Fire Protection Report
Fire District: Falcon Fire Protection District
Parcel ID Nos.: 4313000001
Area/Acreage: ±40.01 AC
Existing Zoning: RR-5

Project Summary: This application includes the requested approval for a proposed site development plan of the 40.01-acre site of seven (7) lots RR-5 zone development. The site plan includes platted boundary descriptions, ROW dedications and improvements, private parking and drives, stormwater and water quality facilities, utilities, pedestrian amenities and landscape buffers and setbacks).

FIRE PROTECTION REPORT

1 ALTERNATIVE HAMMERHEAD/PRIVATE FENCE LAYOUT DETAIL TYPICAL TURN ROUND

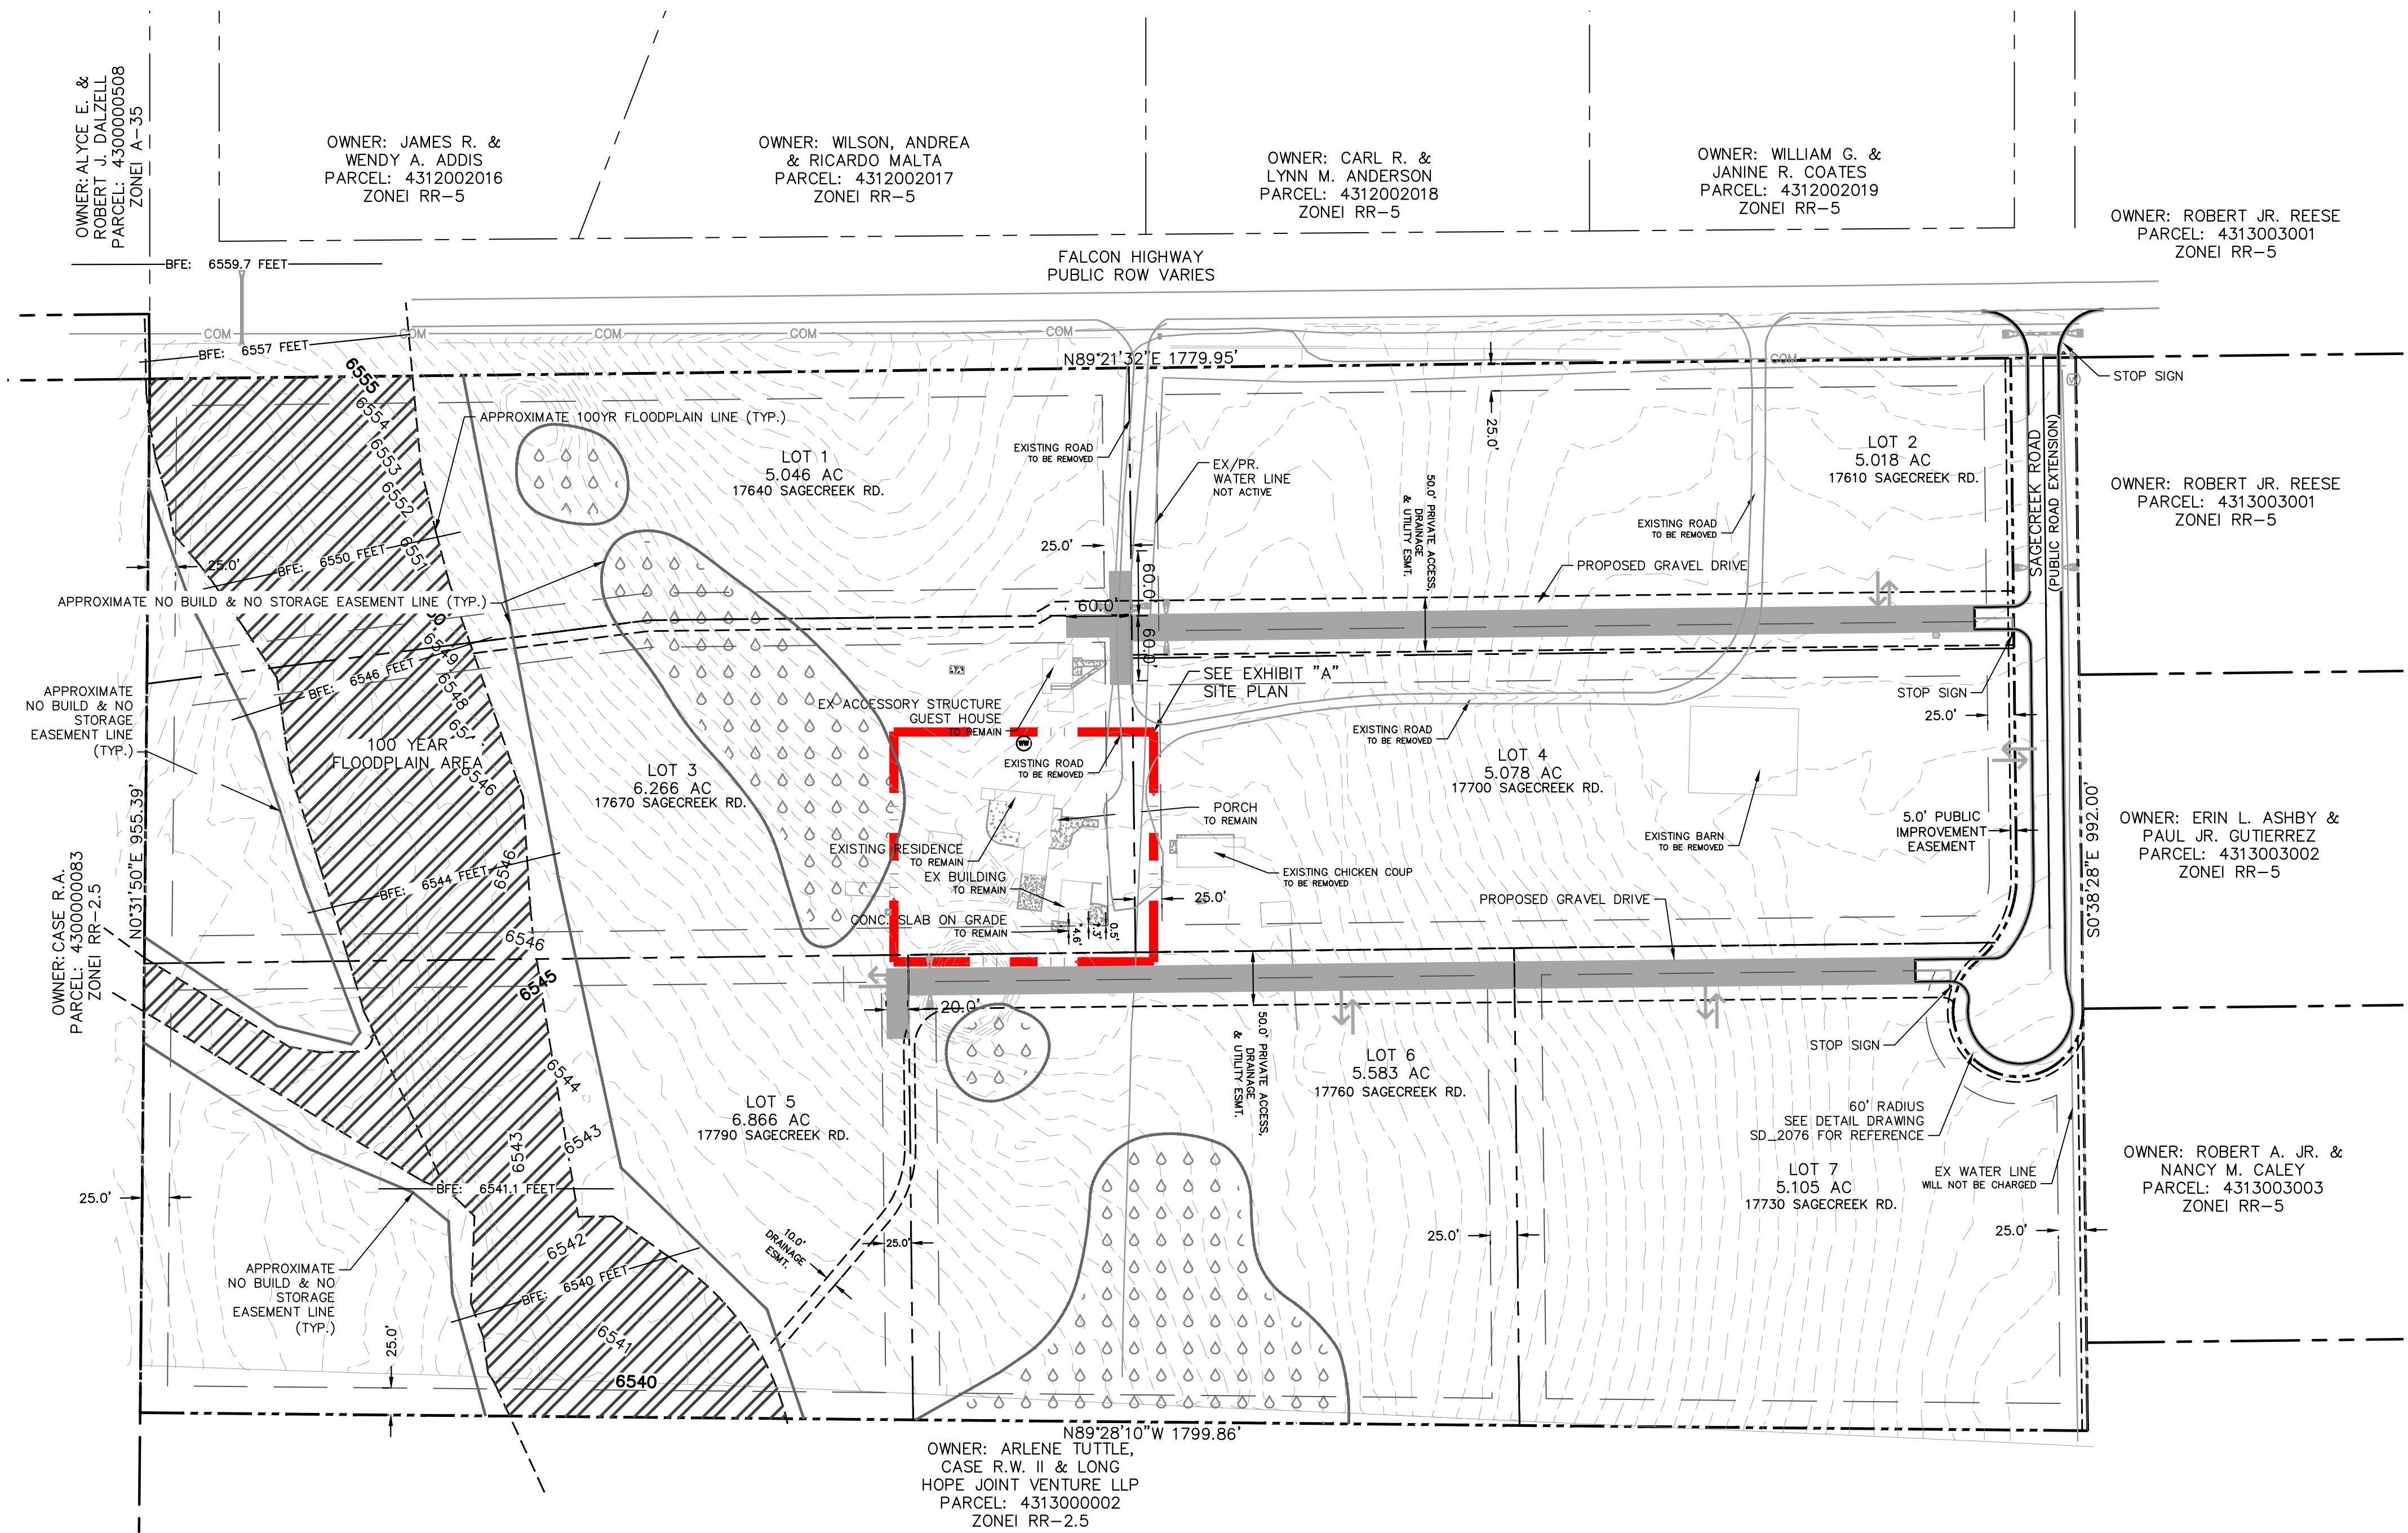
Please see and address Falcon Fire review comments regarding driveway turnarounds.

EXHIBIT "A" SITE PLAN

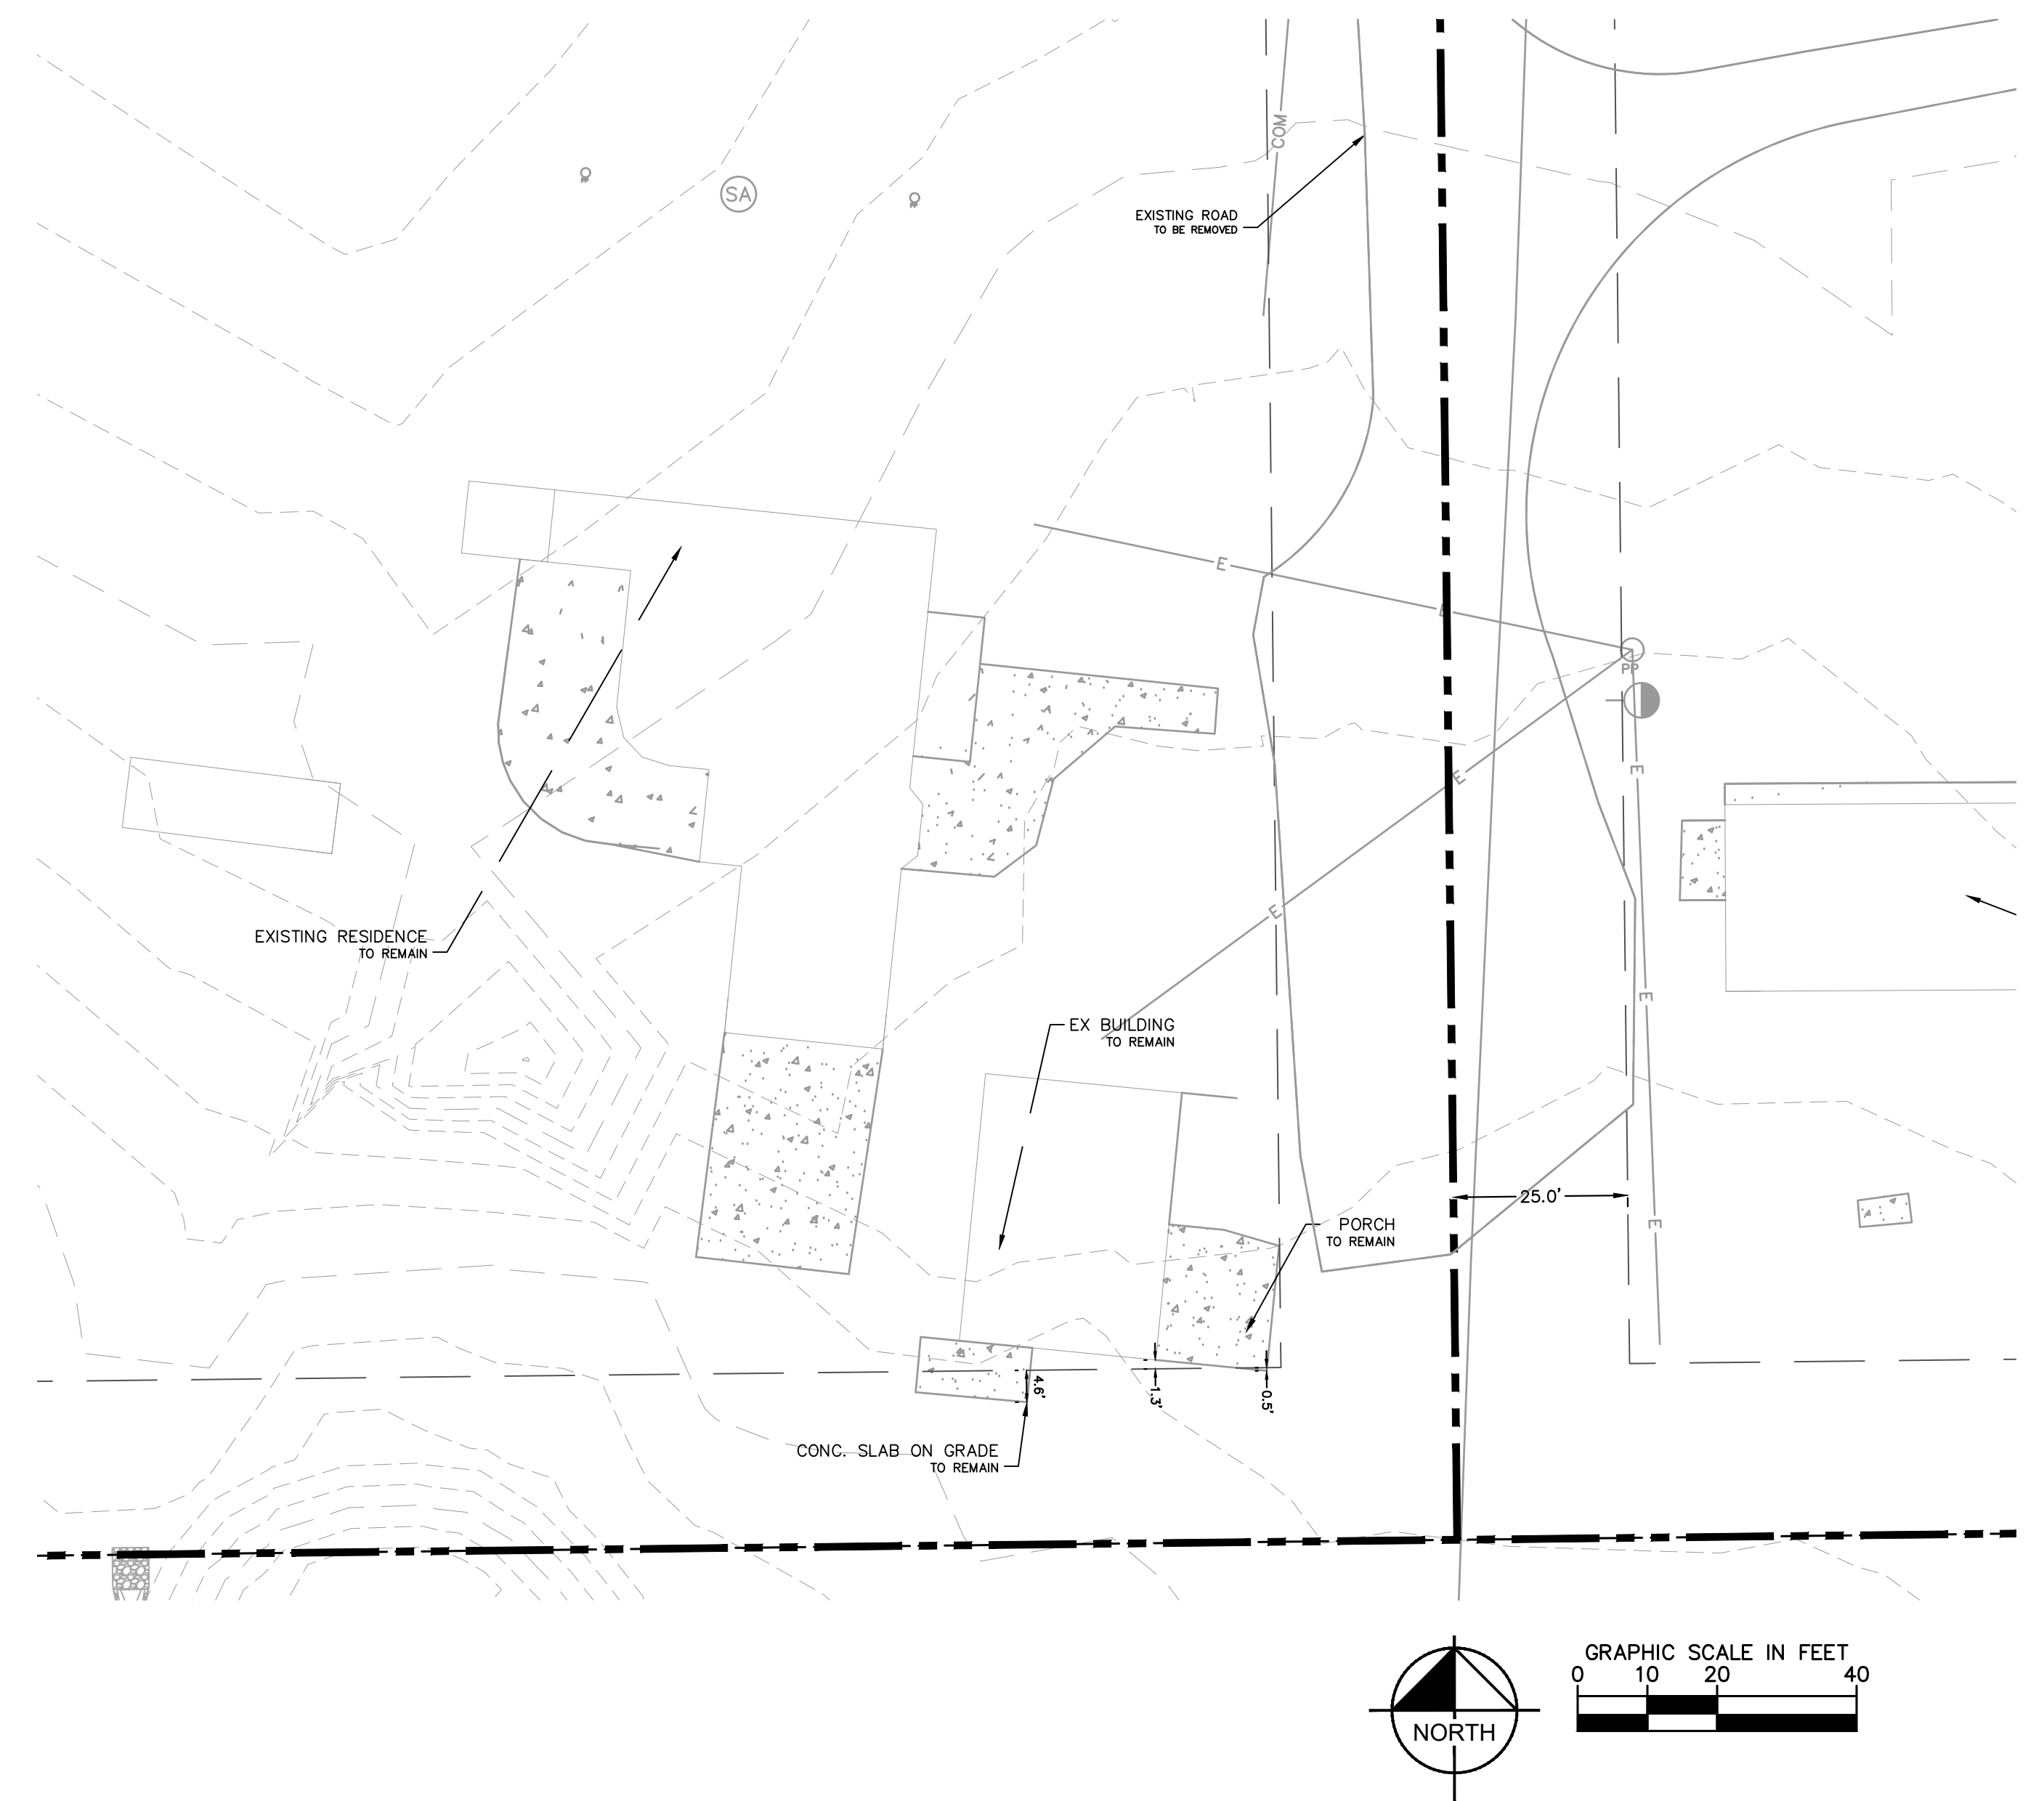
Please depict the location of cisterns in the plat drawing and in the fire report.
